Consultation Response from Mark Berry KC, Highways Development Management
2022/92081 Land at, Huddersfield Road/Leeds Road, Birstall, Batley, WF17 9AA
Demolition of existing buildings and erection of retail food store with associated parking and landscaping
Date Responded: 21-12-2022 Responding Officer: Mark Berry Responding Ref: 13-3SE-33

The applicants have now provided revised plans reference numbers 1620-201C and WLLR-MWA-XX-XX-DR-A-001 P7 showing 16.5m articulated vehicle tracking, a footpath into the site at the eastern end and the re-siting of the bus stop on Leeds Road.

REV	DATE	DESCRIPTION
PROJECT		
LEEDS ROAD & HUDDERSFIELD ROAD, BIRSTALL		
TITLE		
BUS STOP RELOCATION PLAN		
SCALE		
NTS @ A3		
DRAWING		
1620 301		
DATE		
AUG 2023

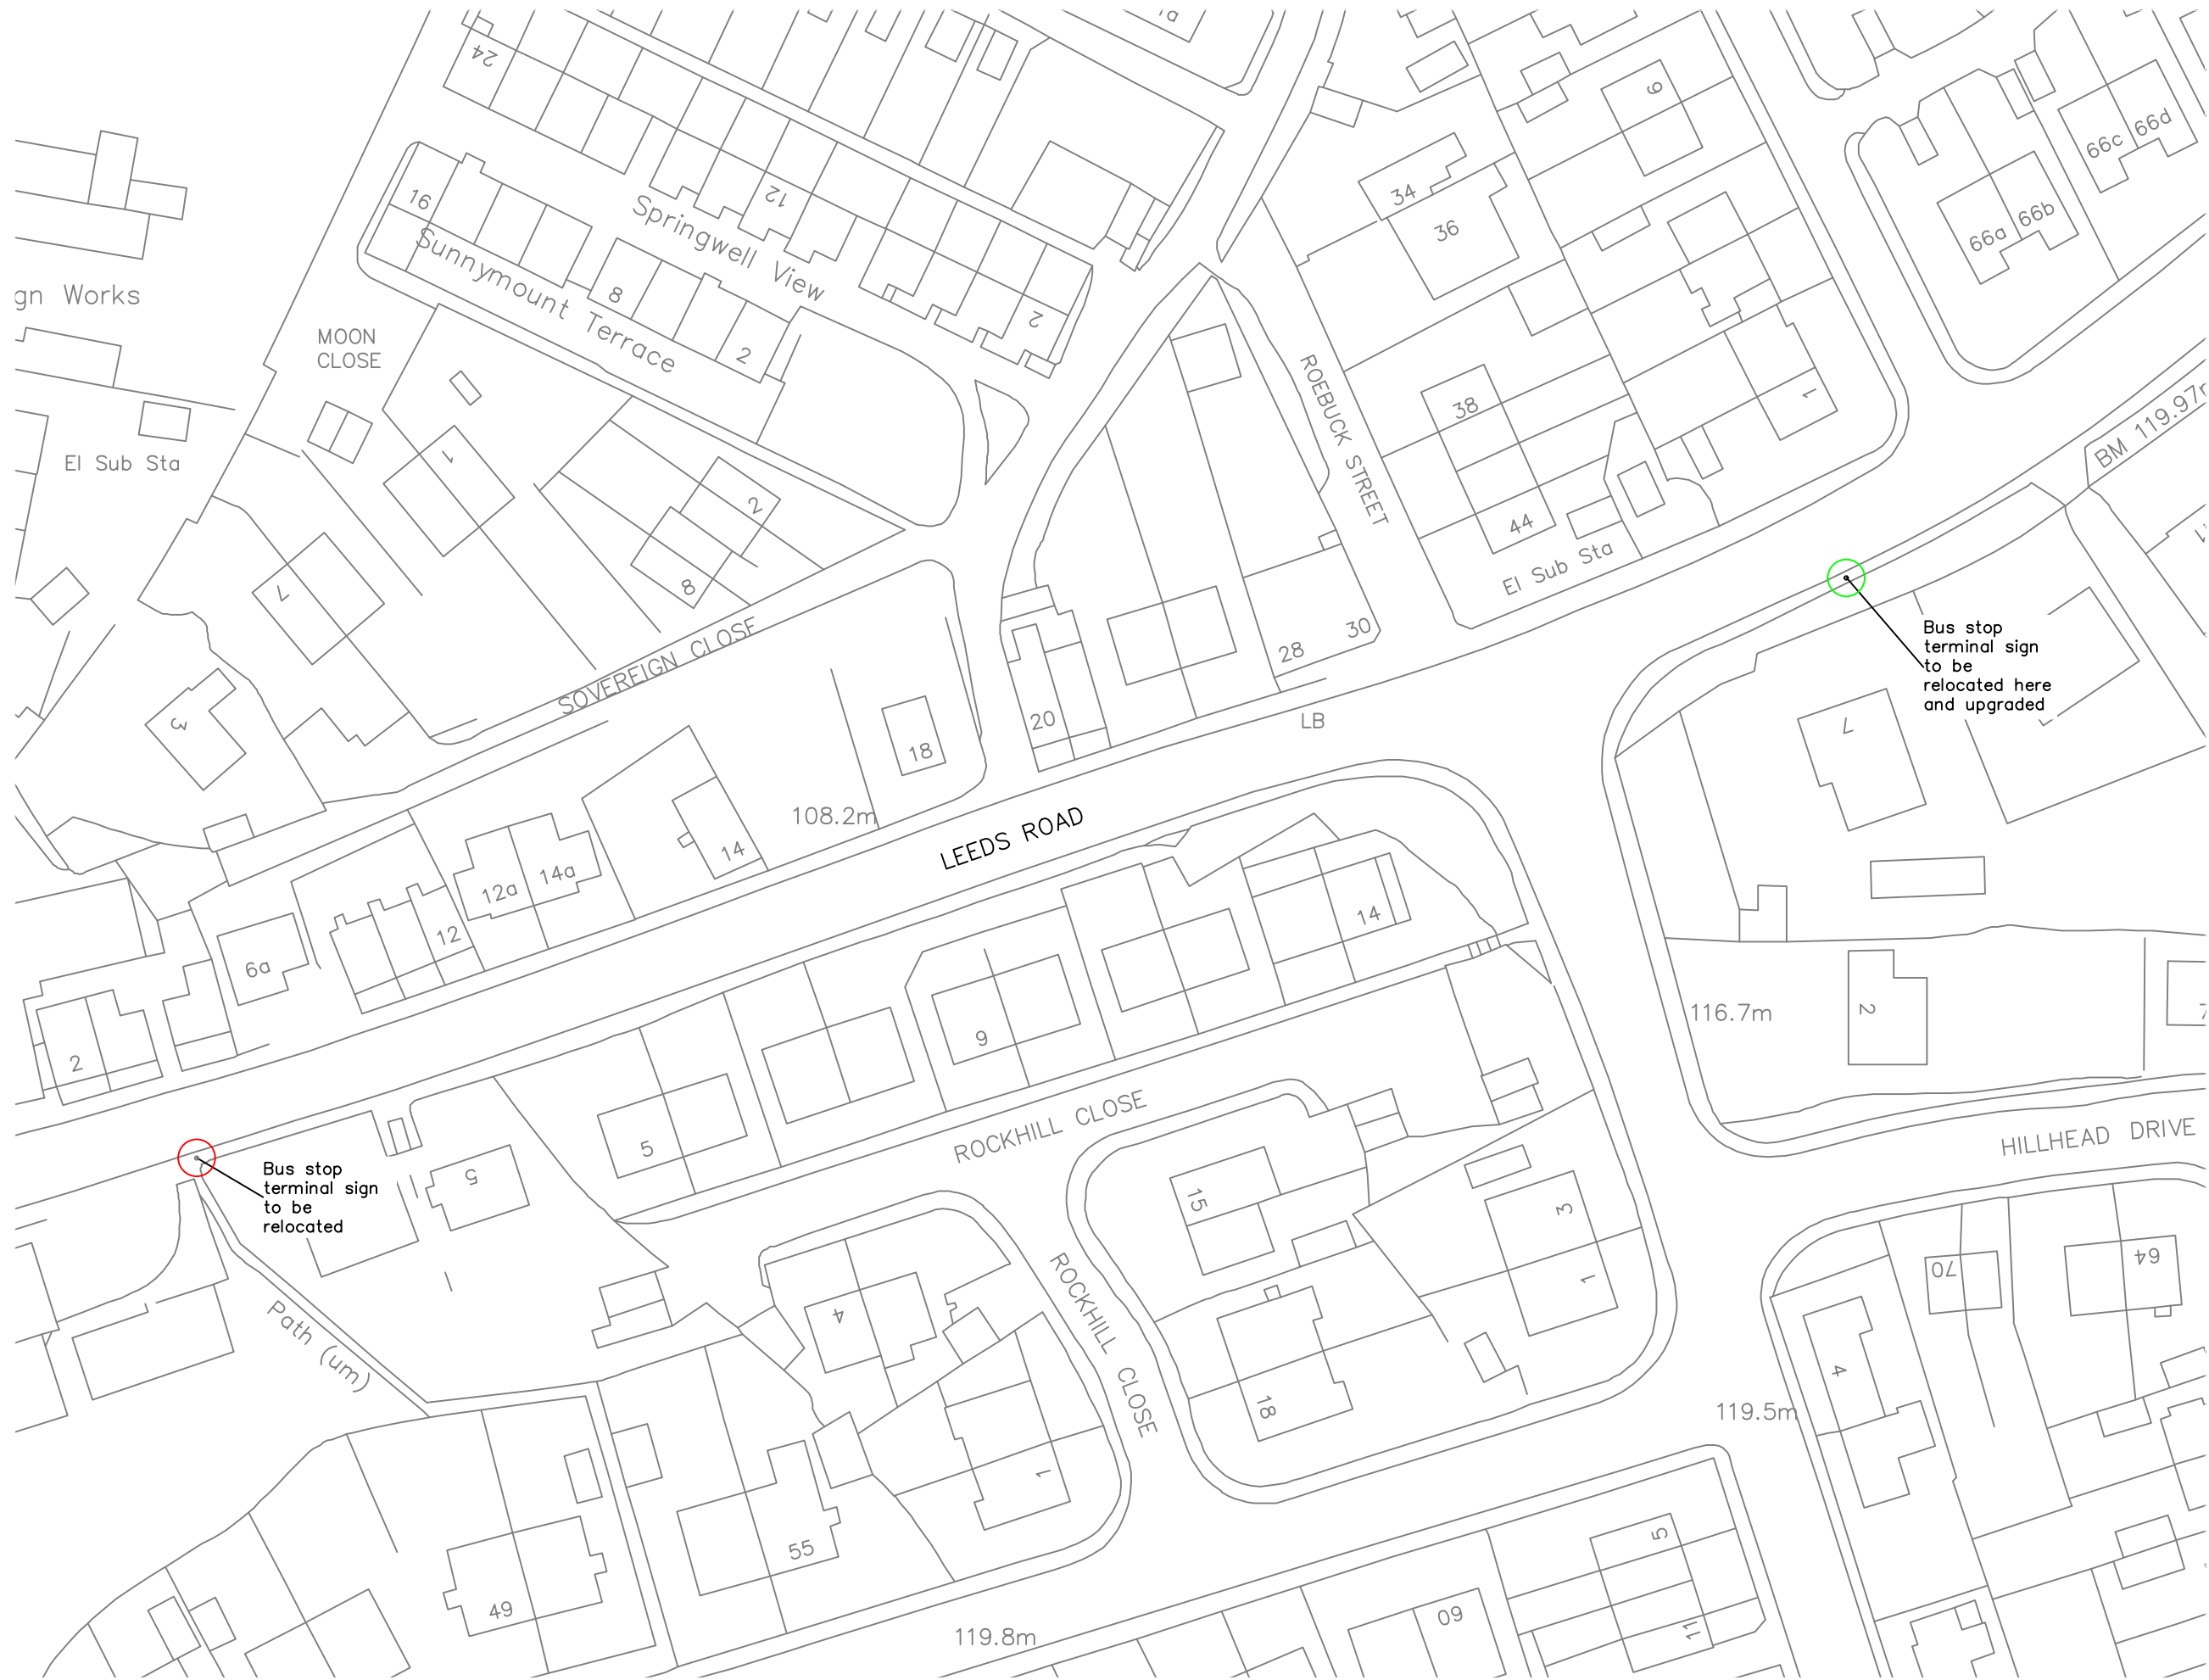
Both the Highway Safety Section and West Yorkshire Combined Authority object to the re-siting of the bus stop to the location shown. The existing footway at this location is too narrow to be considered safe especially for disabled people and people with prams.

File Identifier: Originator: Volume: Level: Type: Role: Number: Revision: WLLR - MWA - XX - XX - DR - A - 1001 P7

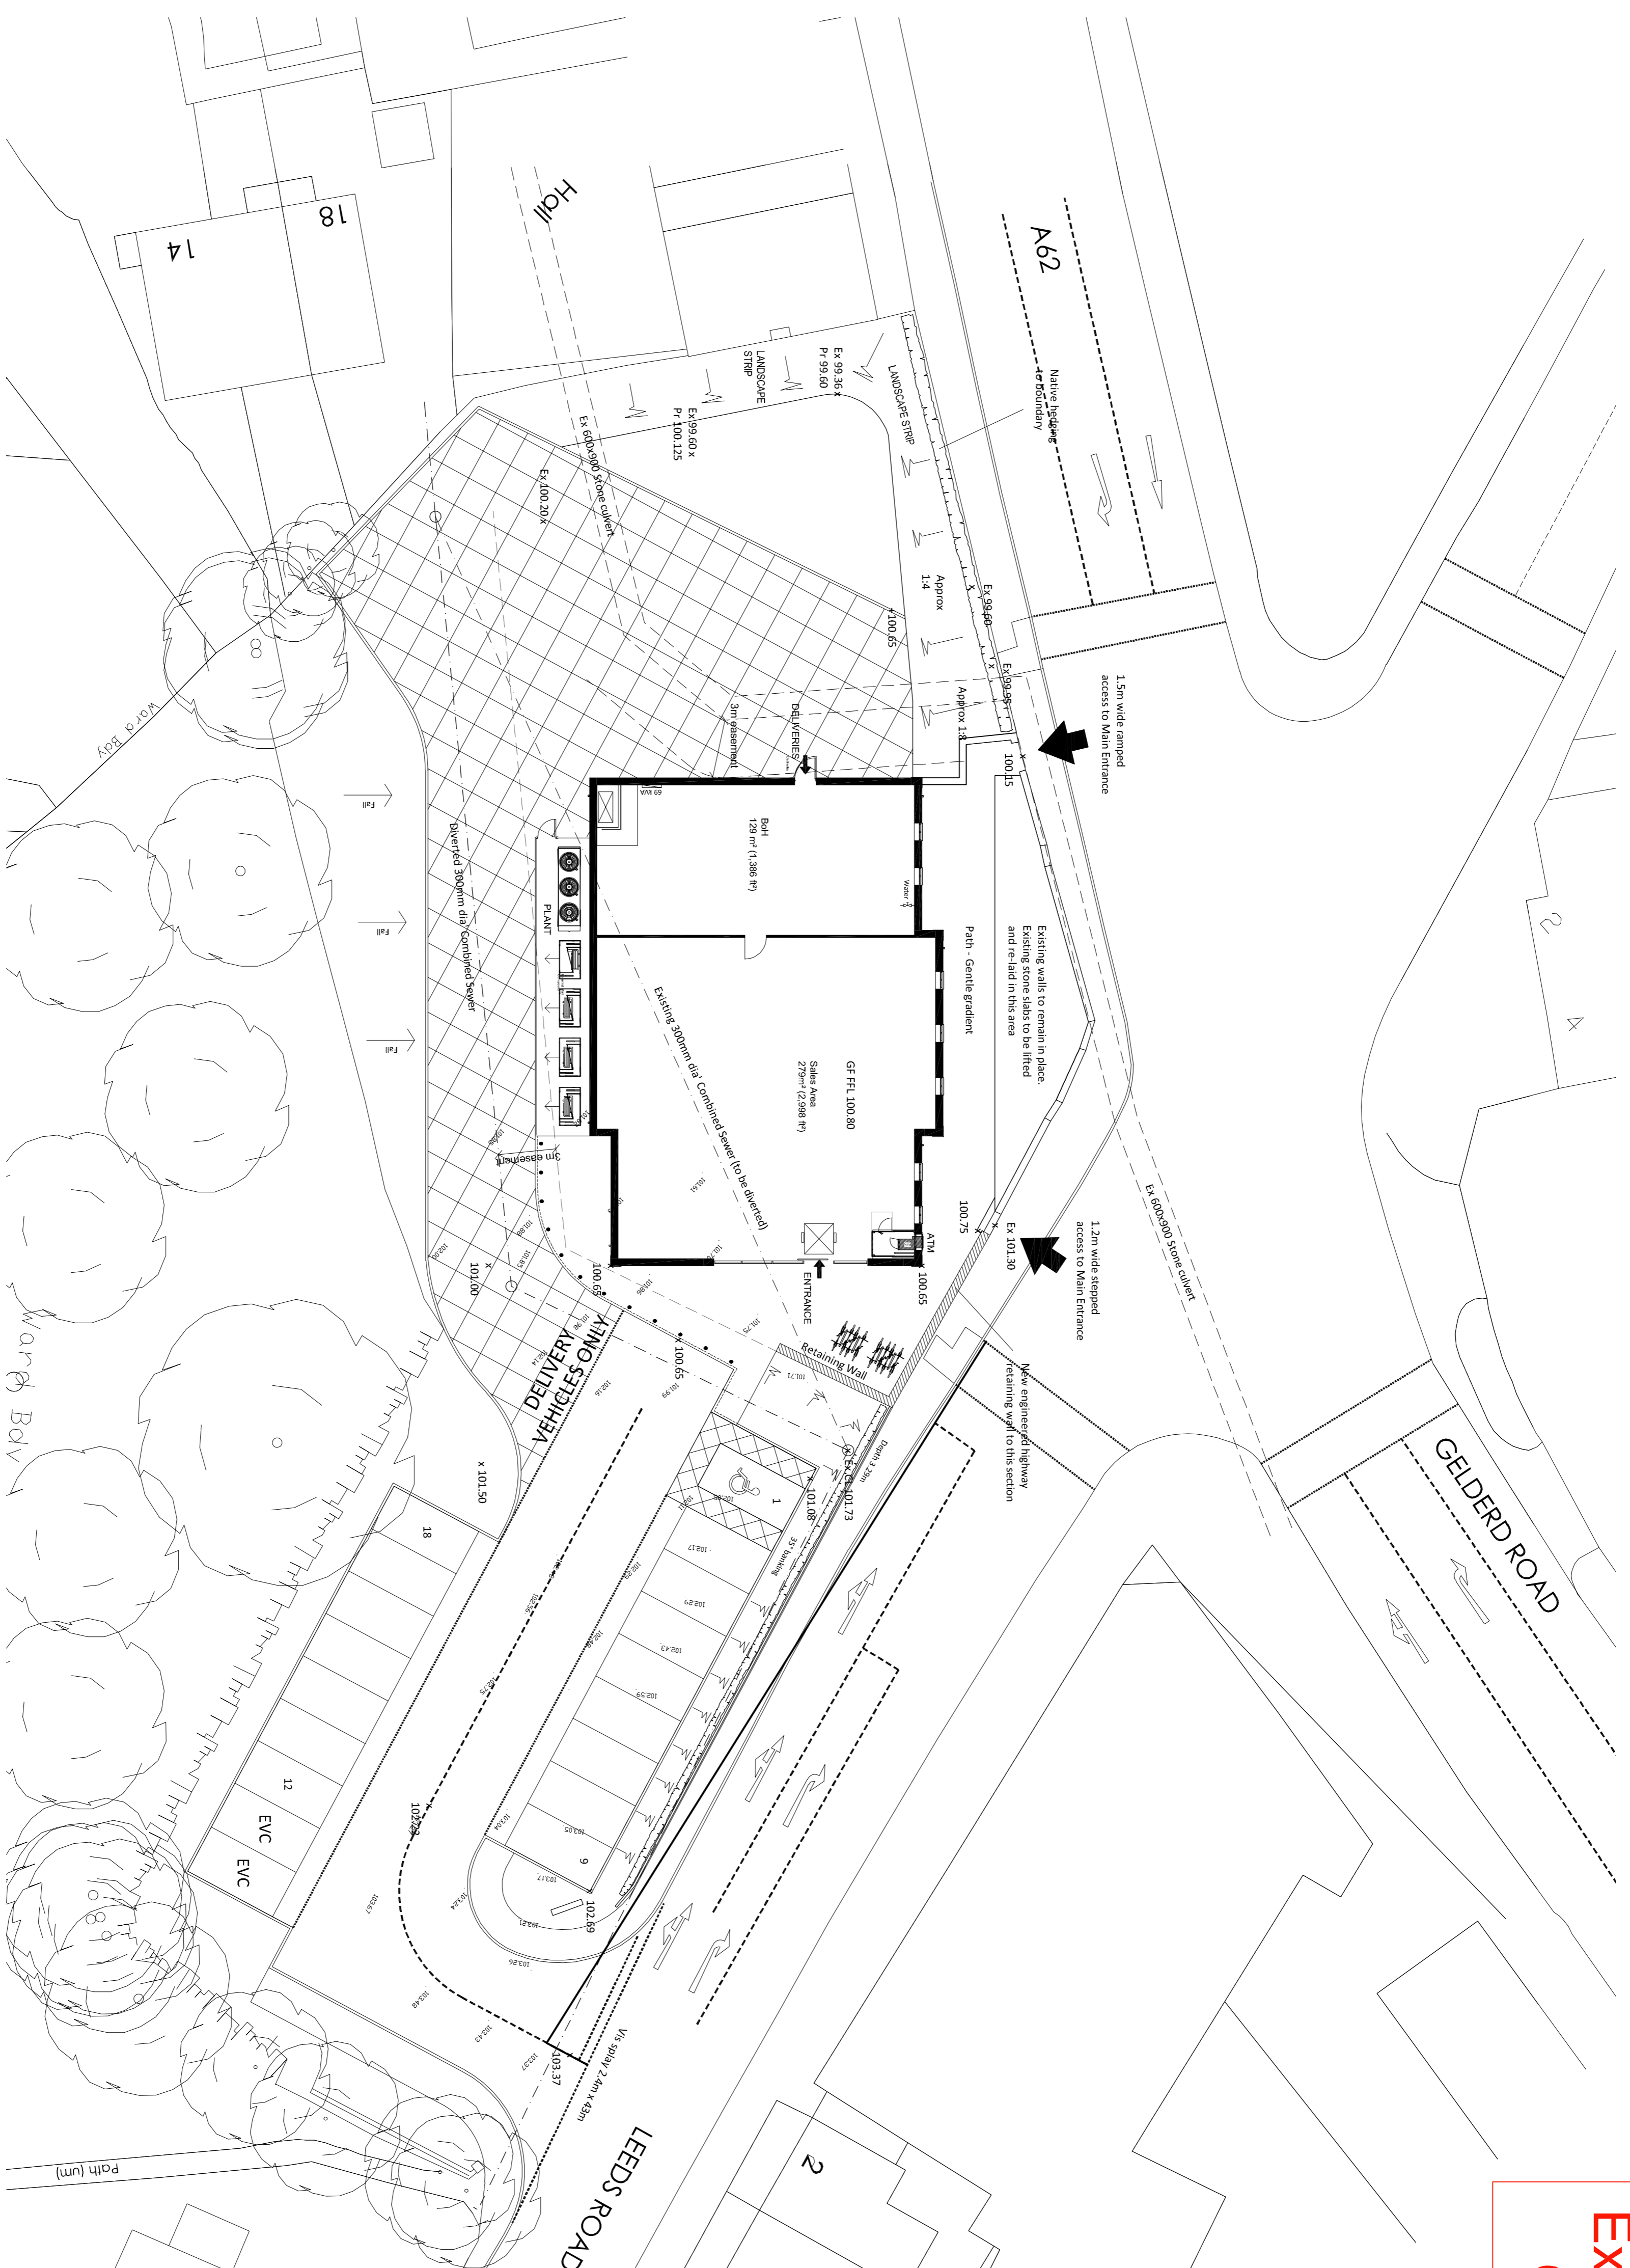
The 16.5m articulated vehicle tracking is far too tight through the site and in the proposed turning space and provides no margin for driver. The swept paths at the entrance show the vehicle effectively needing almost the full width of Leeds Rad to exit the site.
